**Consultation Response from KC,  
Highways Development Management**

**2025/93174 Land Adjacent, 2, Hoyle Ing, Linthwaite, Huddersfield, HD7 5RX**

**Discharge of details reserved by conditions 7 (boundary treatment), 8 (footway), 10 (bat/bird roosting), 11 (Remediation Strategy), 14 (noise), 15 (CEMP) on previous permission 2022/94124 for erection of 2 dwellings (Use Class C3) and associated landscaping and car parking (within a Conservation Area)**

**Recommendation – Partial Discharge**

Drawing Number: LM25123-DYSE-XX-ZZ-DR-C-1003 Revision: P02

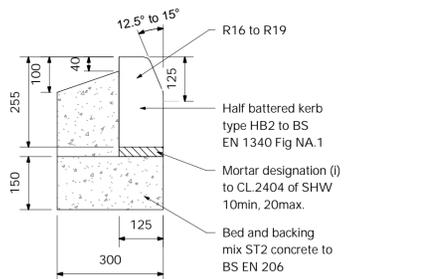
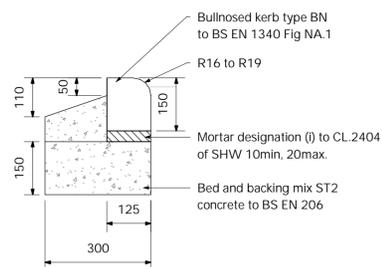
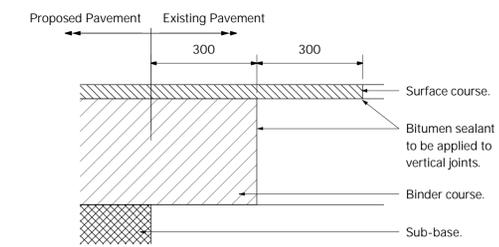
The information submitted is acceptable in principle and in terms of construction detail is sufficient to partially discharge the condition. The second part of the condition goes on to state – “*The development shall not be brought into use until the approved scheme has been completed. The footway shall thereafter be retained as a footpath for use by the public*”, this element of the condition cannot be discharged until the footway has been constructed and dedicated as adopted highway.

Having discussed with colleagues in the Section 38 Team it is considered that a Section 38 Agreement would be disproportionate for such a small area of works, would take considerable time to conclude and is likely to be costly in terms of legal fees and bond arrangements. Section 38 have advised that the APC (Advanced Payment Code) would be a more appropriate mechanism for works of this scale. Once the works are completed and approved, a Deed of Dedication would then be required to dedicate the footway as adopted highway.

To initiate this process and fully discharge the condition the Applicant must contact the Section 38 team at [Highways.Section38@kirklees.gov.uk](mailto:Highways.Section38@kirklees.gov.uk) who can ensure the correct processes are followed and financial surety secured.
